Chelmsford City Council

LOSF - 002

Written Summary of Comments made during ISH2 (Environmental Matters) Hearing 29th September 2022

Longfield Solar Farm

## Stocks Farm

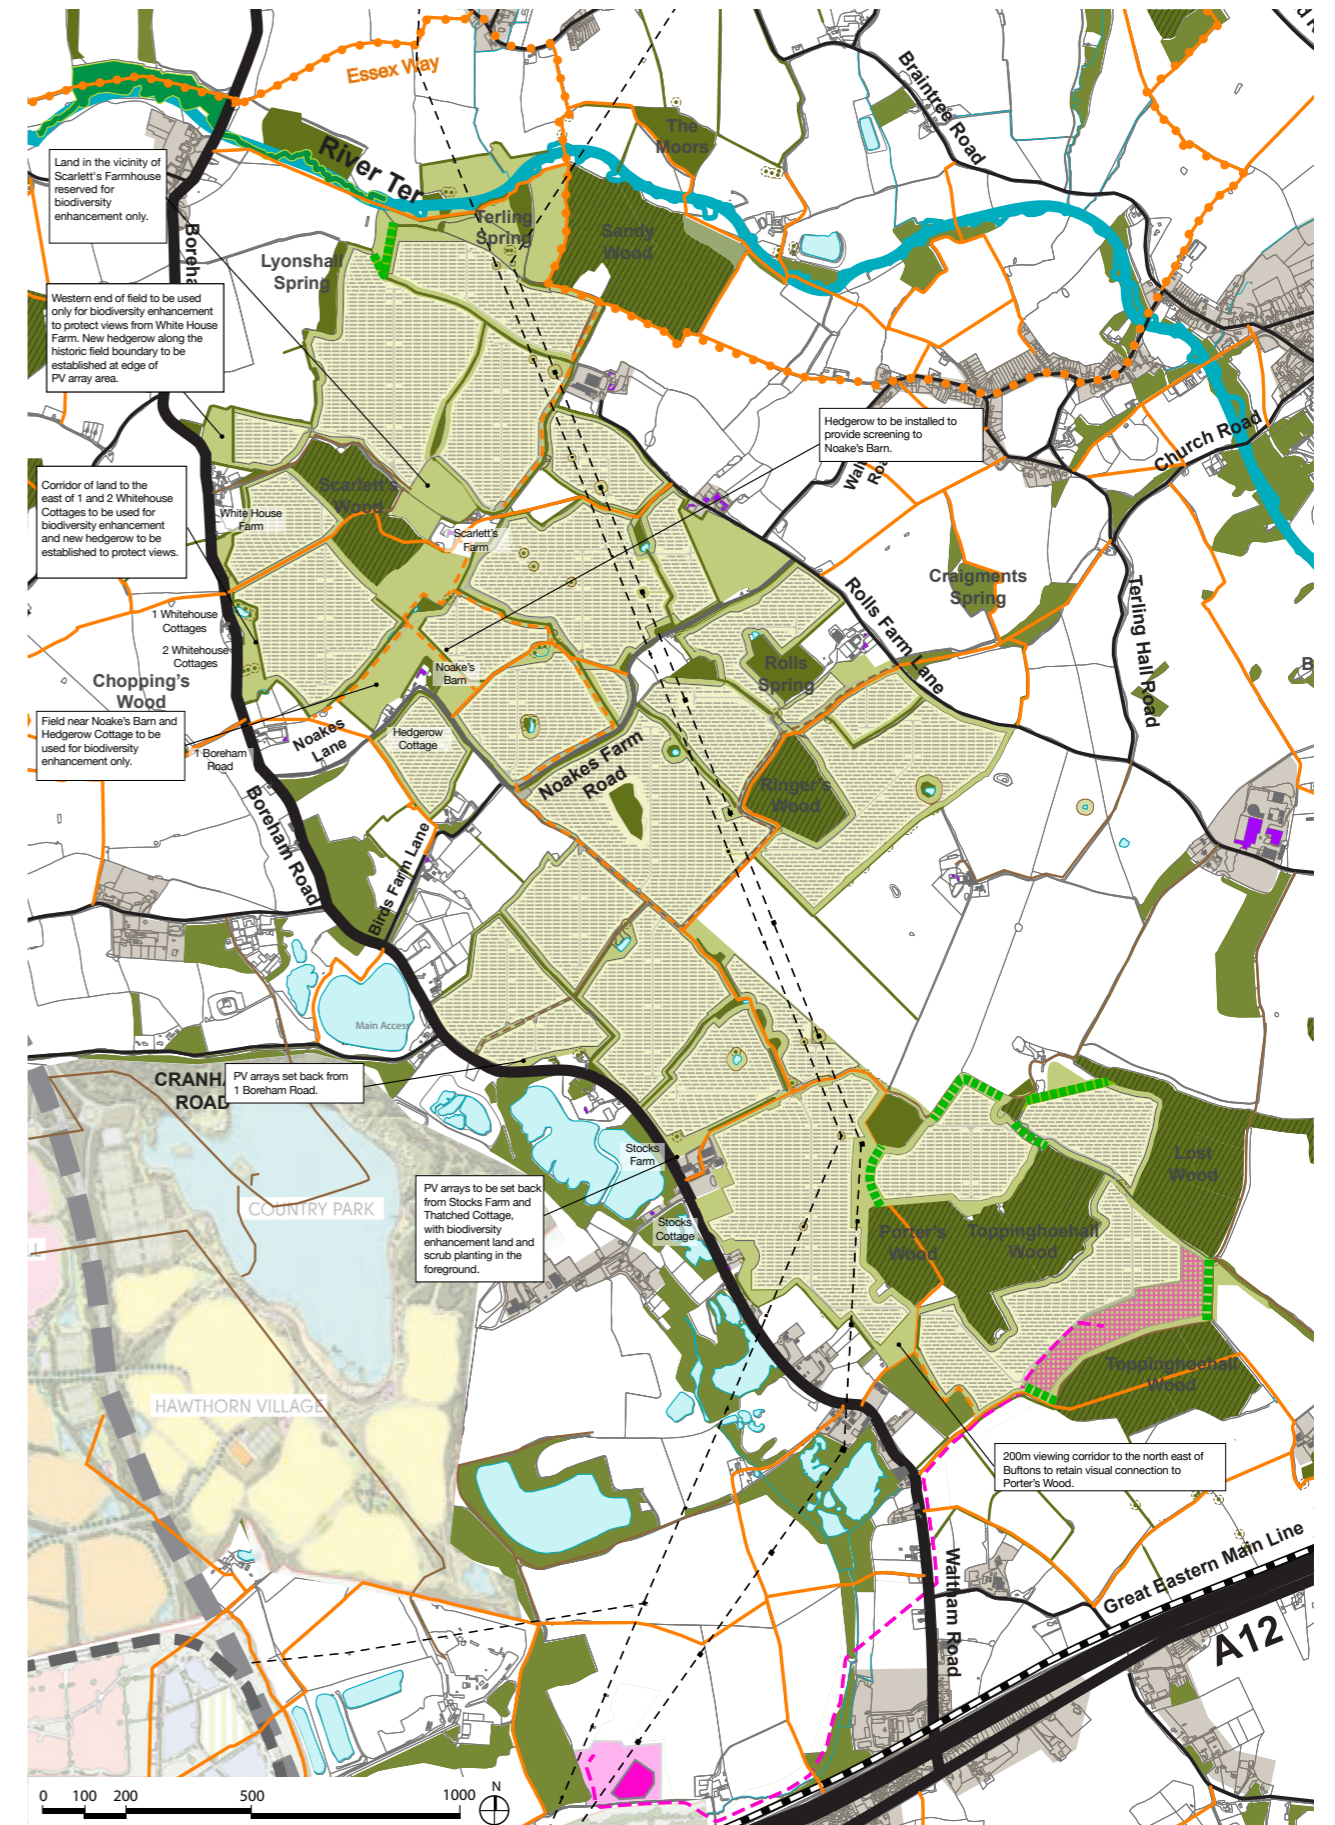
Stocks Farm is an early nineteenth or eighteenth century farmhouse. Because of its architectural and historic interest it is a non designated heritage asset. To the rear of the site there are also a group of farm buildings, including a traditional a barn, two outbuildings and a twentieth Dutch barn to the north east. The traditional farm buildings are also considered to be non designated heritage assets. This is a matter of agreement. The environmental statement grades the farmhouse as being of low significance and the magnitude of impact as low, resulting in a negligible impact.

It is considered the farmhouse and traditional farm buildings should be classed as being of medium significance for the following reasons:

- The framework for assessment (table 7-1 of the ES) for medium significance includes non designated heritage assets of regional research value. The East of England Research Framework by ALGAO (2011, updated 2019-20) defines post medieval farmsteads as a research priority.
- The listing survey for Chelmsford was undertaken in the mid 1970's, unlikely many other areas there was no accelerated resurvey undertaken in the 1980/90s. For this reason the listing coverage is no comprehensive. The buildings are potentially of listable value, as a group of pre-1840s structures relating to a well preserved farmstead.
- The environmental statement assessment does not assess the significance of group value of the

traditional farm buildings.

It is considered the magnitude of impact should be medium for the reasons below:

- The solar development would wrap around three sides of the site and introduce alien features into the rural landscape.
- The rural setting is important to how the heritage assets are experienced, which would be markedly changed.
- There is a group value with Stocks Cottages to the south (also a non designated heritage asset) which would be eroded.
- The environment statement assessment does not take account of the impact on the non designated heritage asset farm buildings and the close proximity of development to them.
- The setback of the panels on the western edge of PDA28, adjacent Waltham Road, appears contrived and unrelated to the context or any site features.
- Screening in winter months will be minimal.

A medium significance and medium impact would amount to a moderate environmental impact, significant for the purposes of the EIA. This indicates additional mitigation should be provided.

A suggested approach is to move the panels back on the western side of PDA28, to follow the now lost historic field boundary which ran north-south from the rear boundary of Stocks Farm, as indicated on the 1874 OS plan below:

This mitigation would likely reduce the impacts to low, resulting in a minor environment effect, not significance for the purposes of the EIA.
